Consultation Response from: KC Environmental Health (Pollution & Noise Control)
2022/93522 first floor, 27 Market Street, Milnsbridge, Huddersfield, HD3 4ND
Prior notification for change of use from Commercial, Business and Service (Use Class E) to one dwellinghouse (Use Class C3) (within a Conservation Area)
Responding Date:
21st November 2022

Responding Ref:
WK202237122

Drawing Title
 First Floor Plan

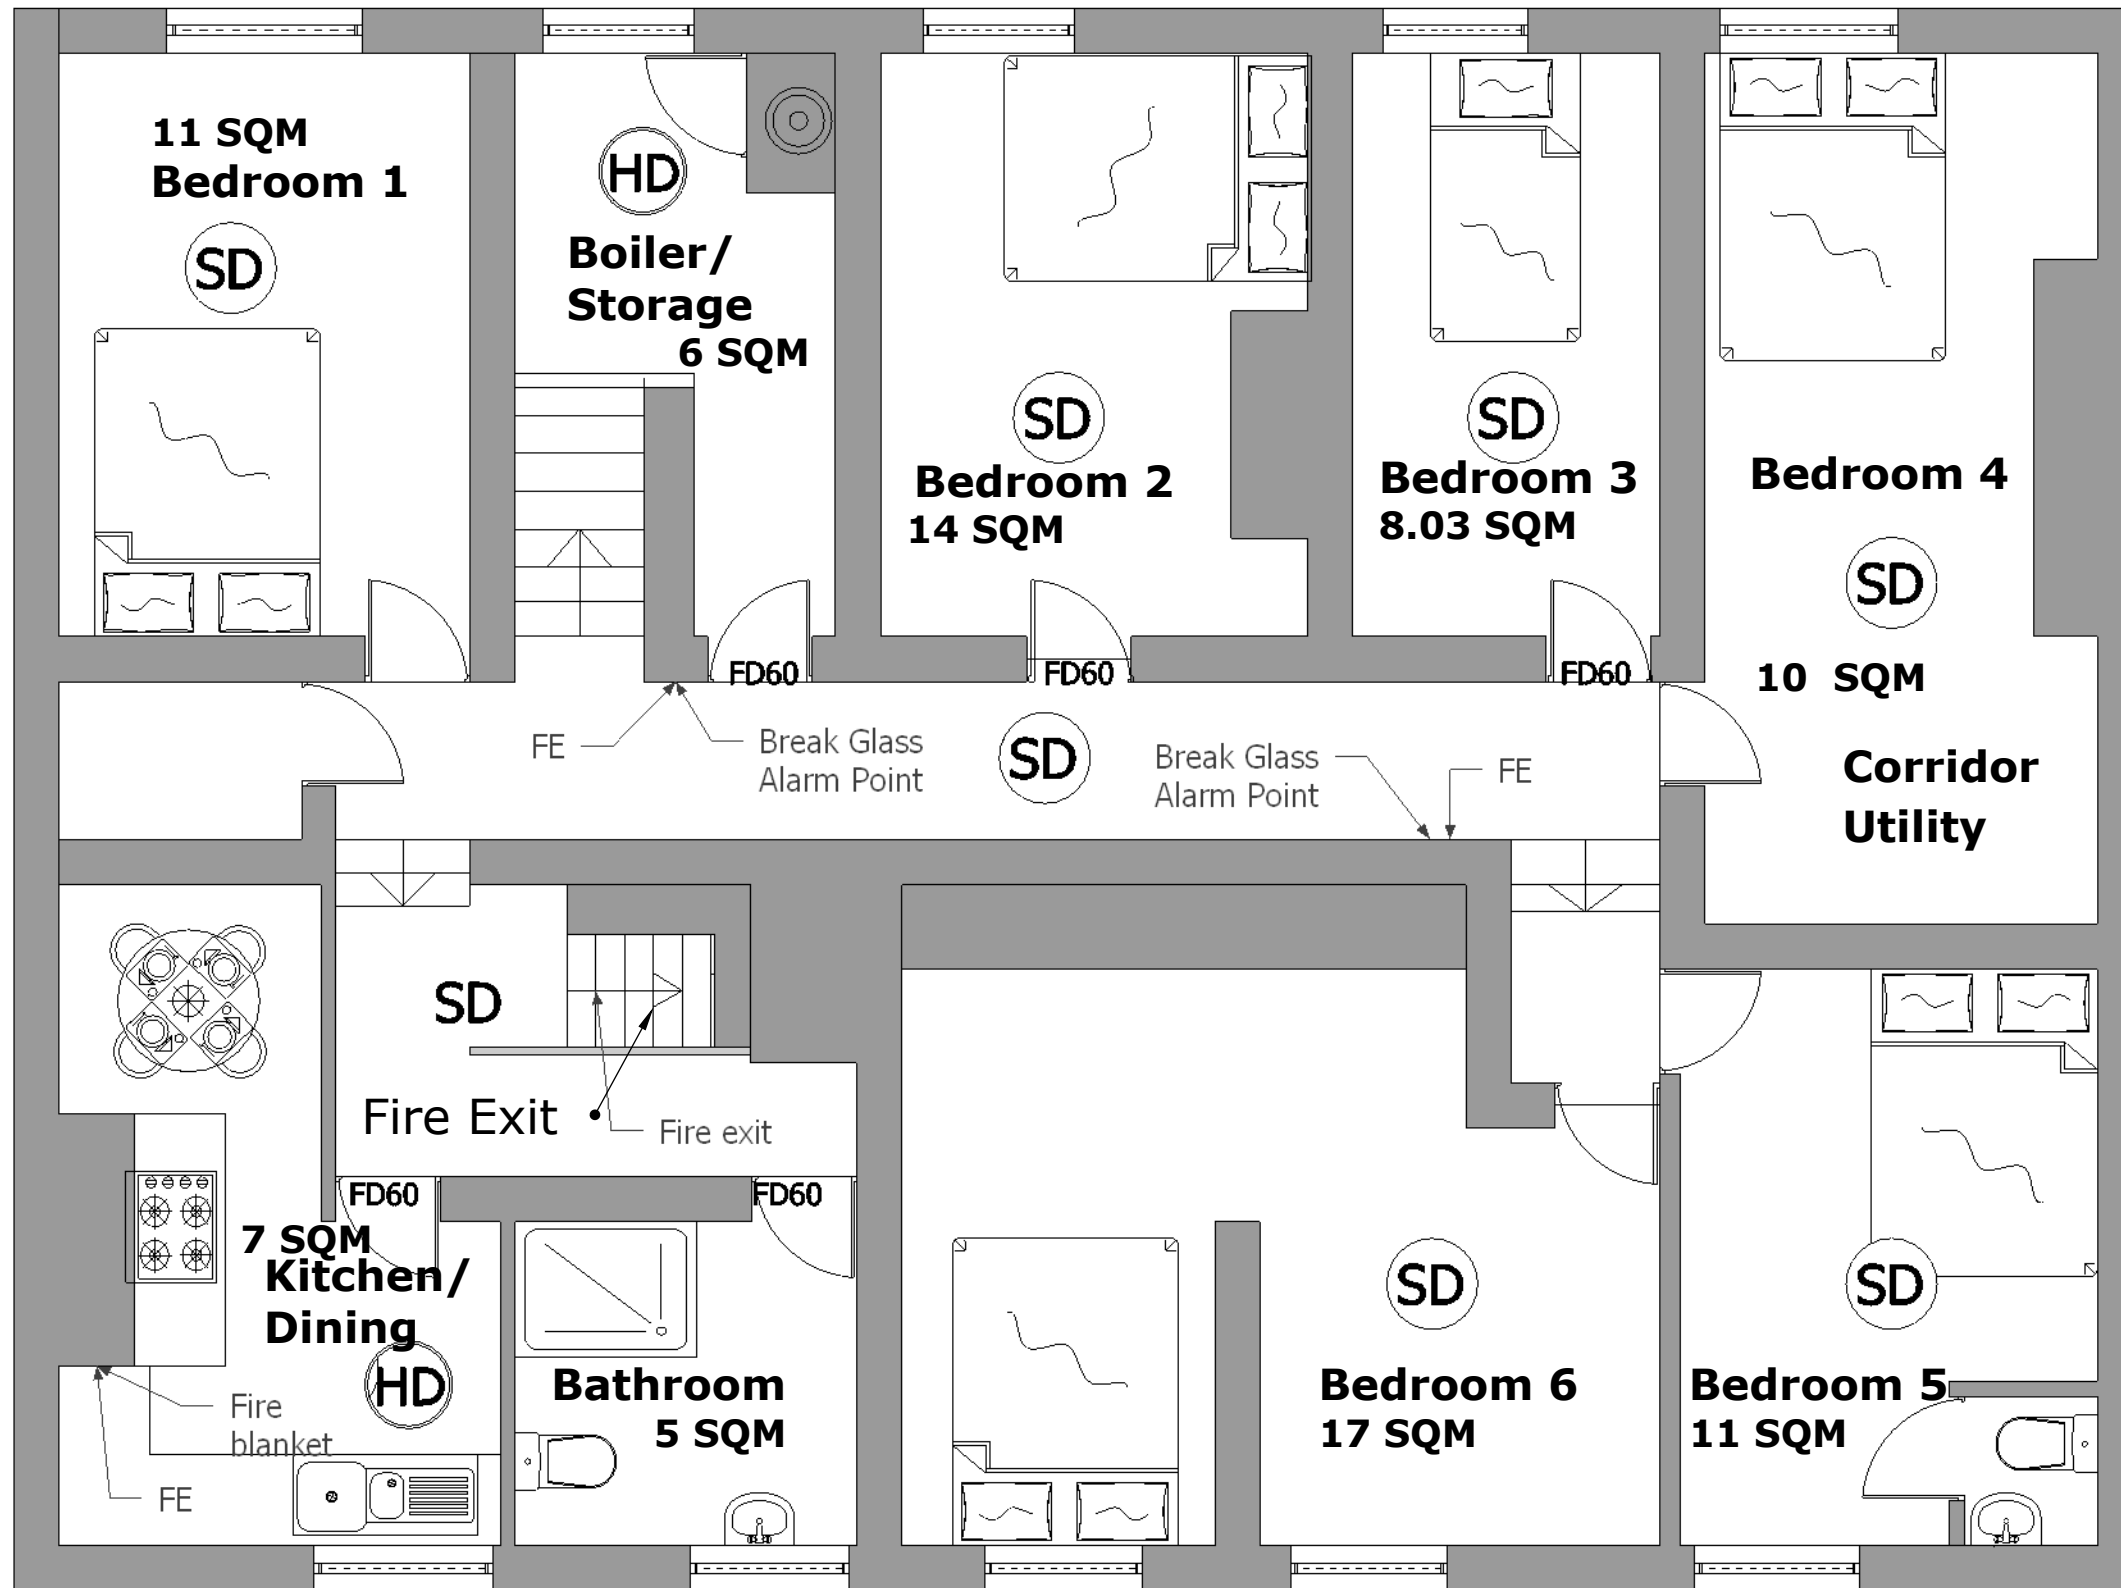
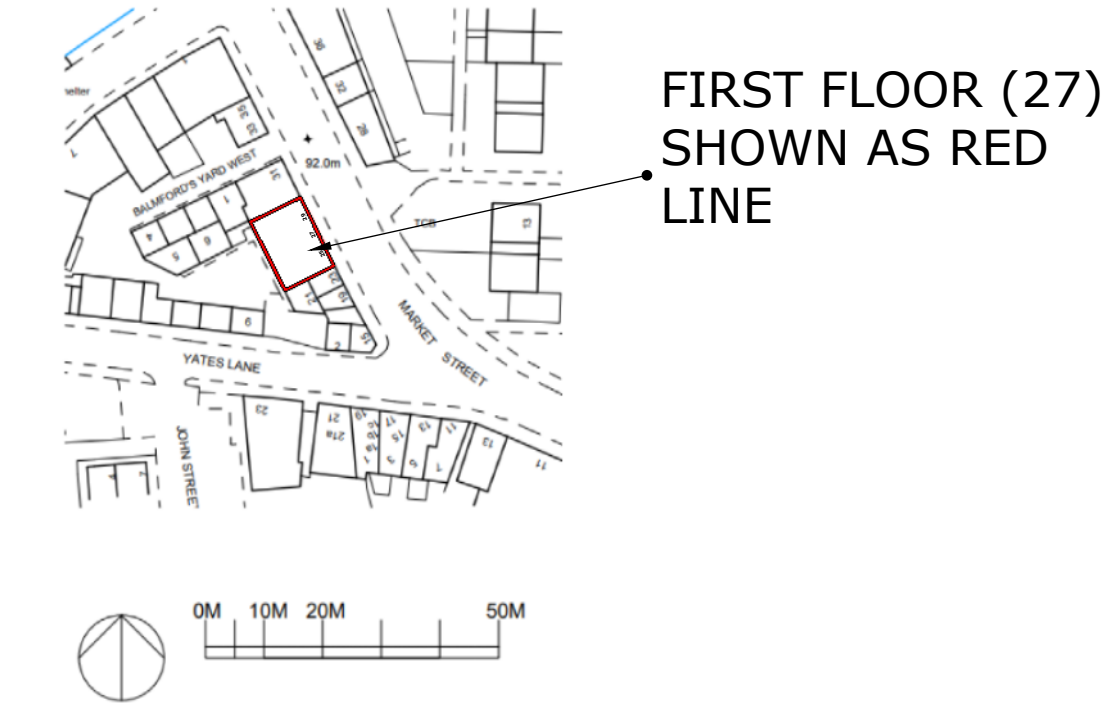
We are concerned that noise from commercial premises and possibly road traffic will detrimentally impact the amenity of future occupiers. The proposed residential units have large windows opening out onto busy town centre streets and rear service yards. Noise sources include but are not limited to, multiple commercial premises, road traffic, customers and delivery vehicles and the wall mounted plant to the rear. Therefore, it will be necessary for a condition requiring a noise report to assess the impact that existing commercial noise sources and traffic will have on the future occupiers of the proposed development.

The proposed residential units on the first floor share a party floor/wall with commercial premises, therefore a condition is necessary to protect the amenity of future occupiers from noise.

Before the development is brought into use the developer shall provide written evidence to the Local Planning Authority to demonstrate that the airborne sound insulation performance of the party floor/wall of the development is of a minimum of 55 dB Dntw + Ctr.
